PLANNING AMENDMENT

H23/0180/00

EXTENSION TO PROVIDE GARAGING AND
PROVISION OF ADDITIONAL VEHICULAR ACCESS

991103/01 ; 991103/01 REV. A.

PROPOSED ELEVATIONS 1:100

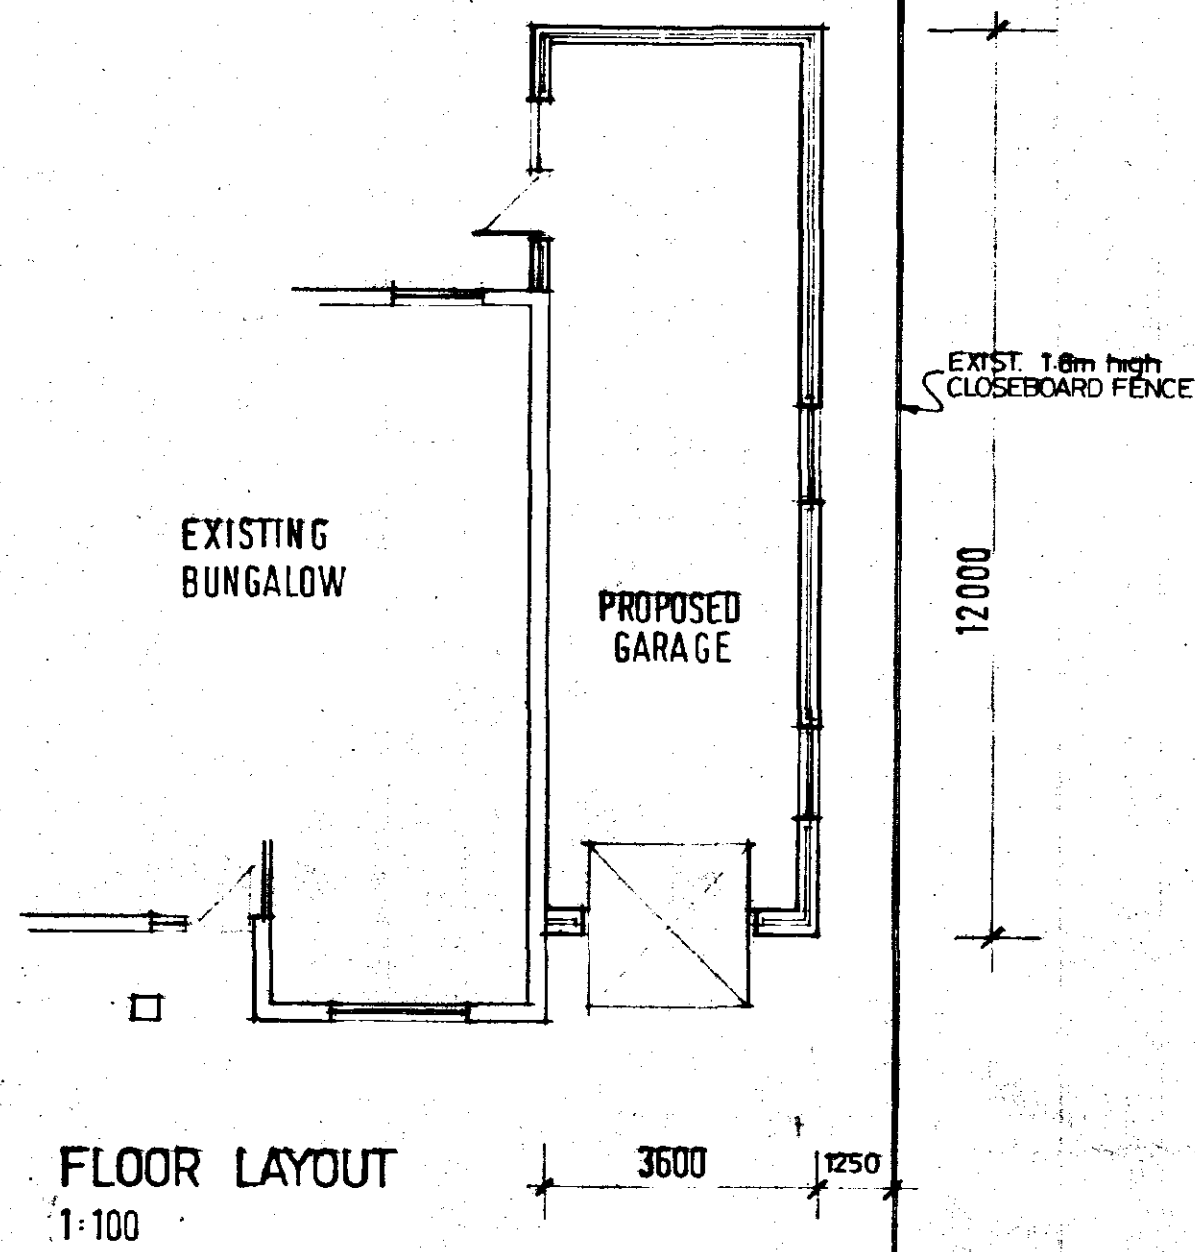
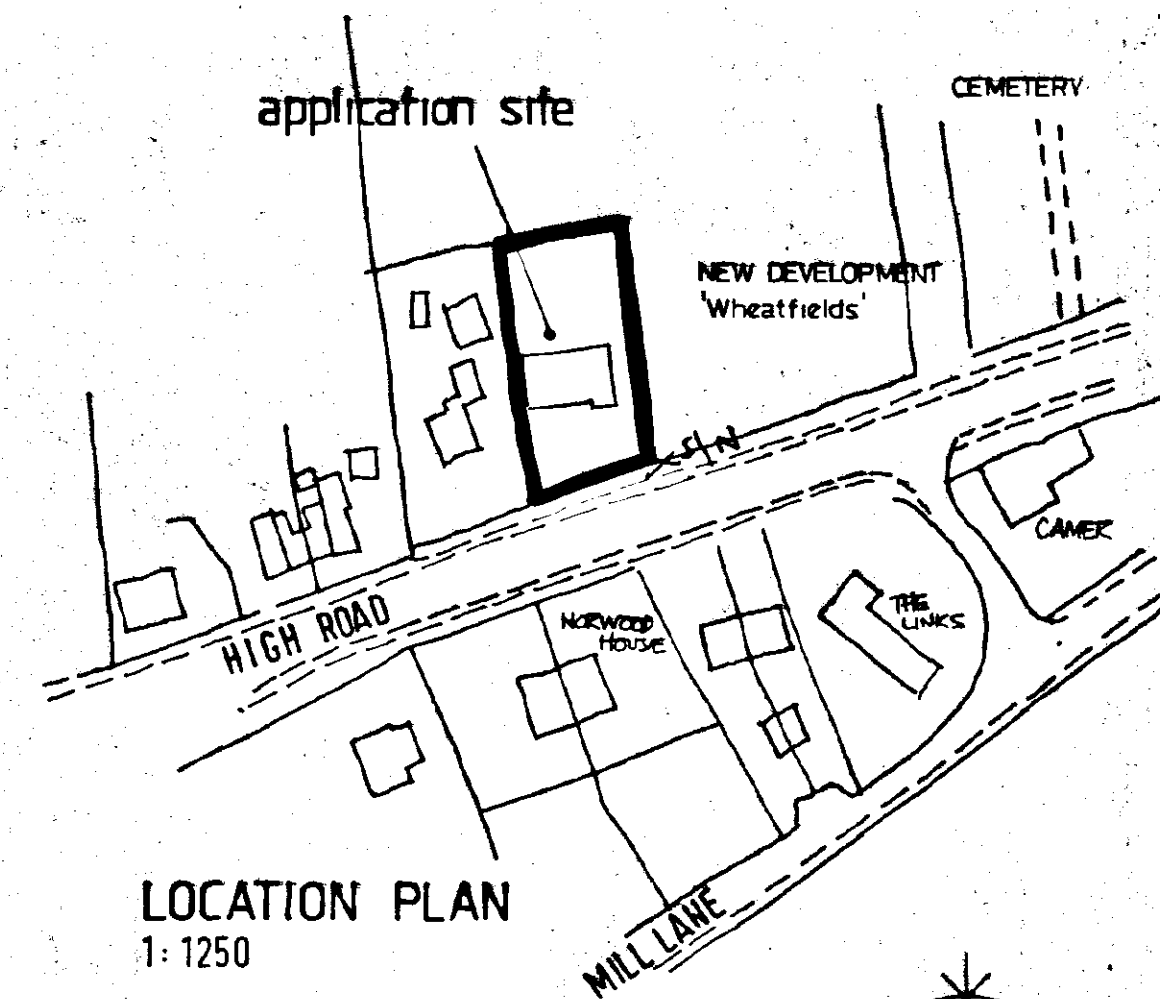
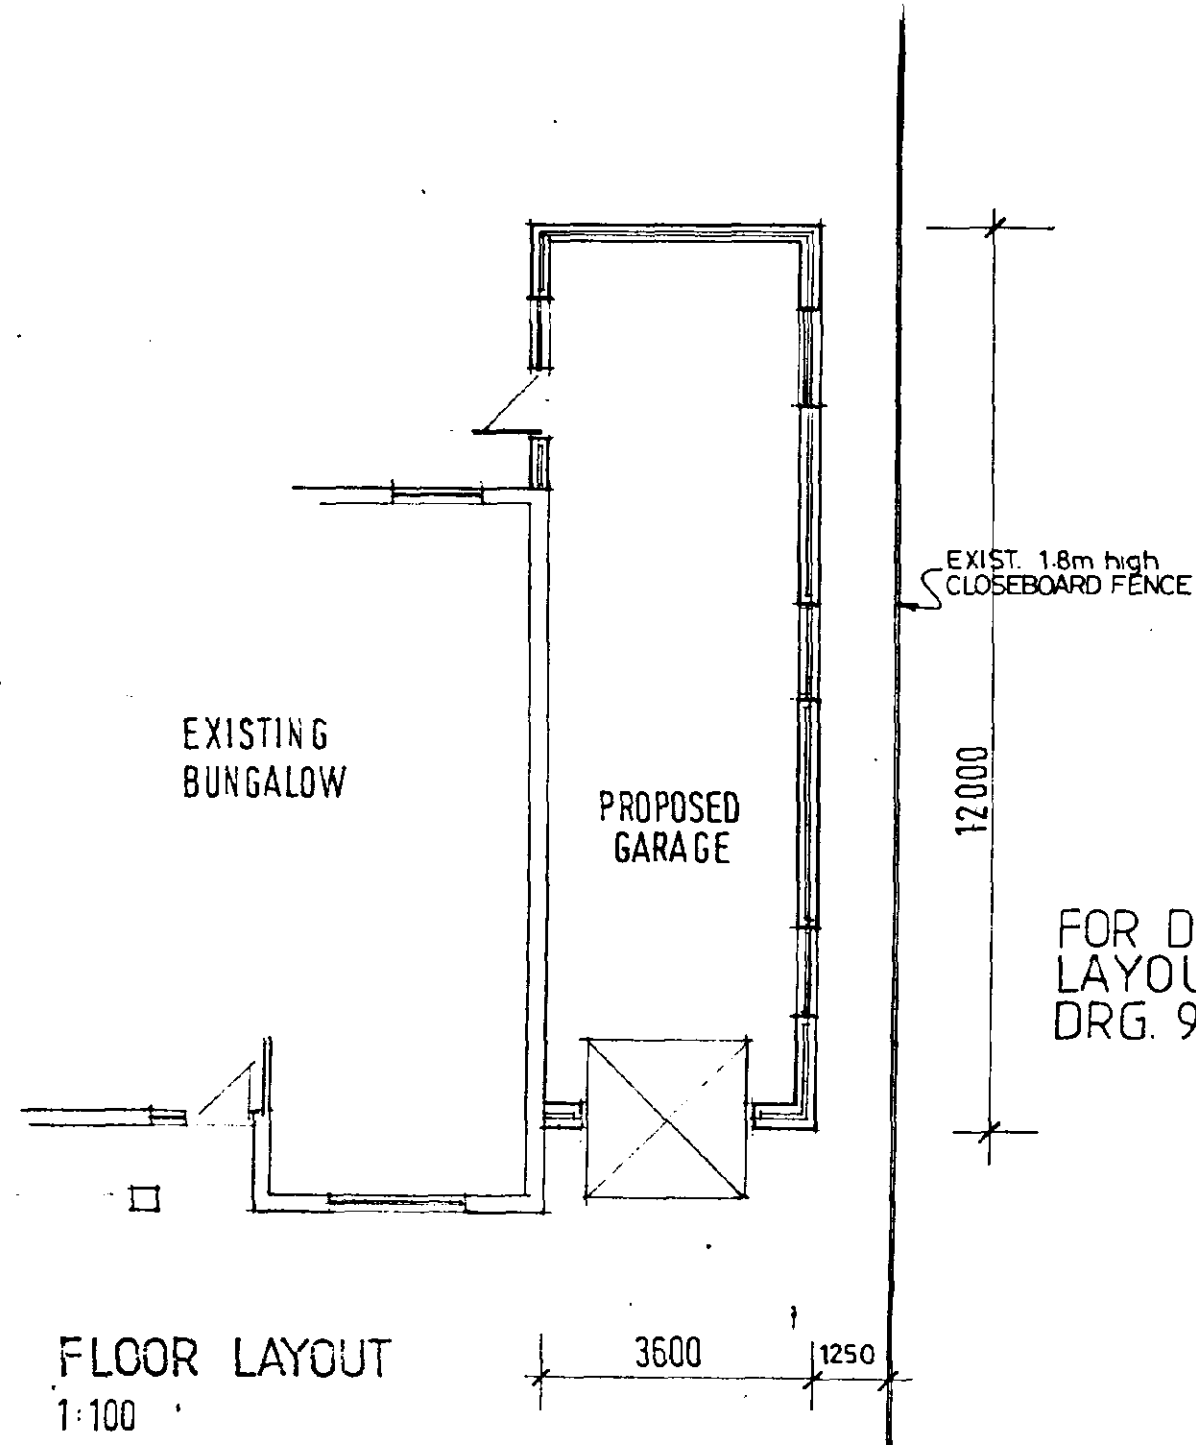
ADDITIONAL HIGH LEVEL WINDOW TO SIDE
ELEVATION
WINDOW DEPTHS REDUCED TO 350mm
ALONG EAST ELEVATION
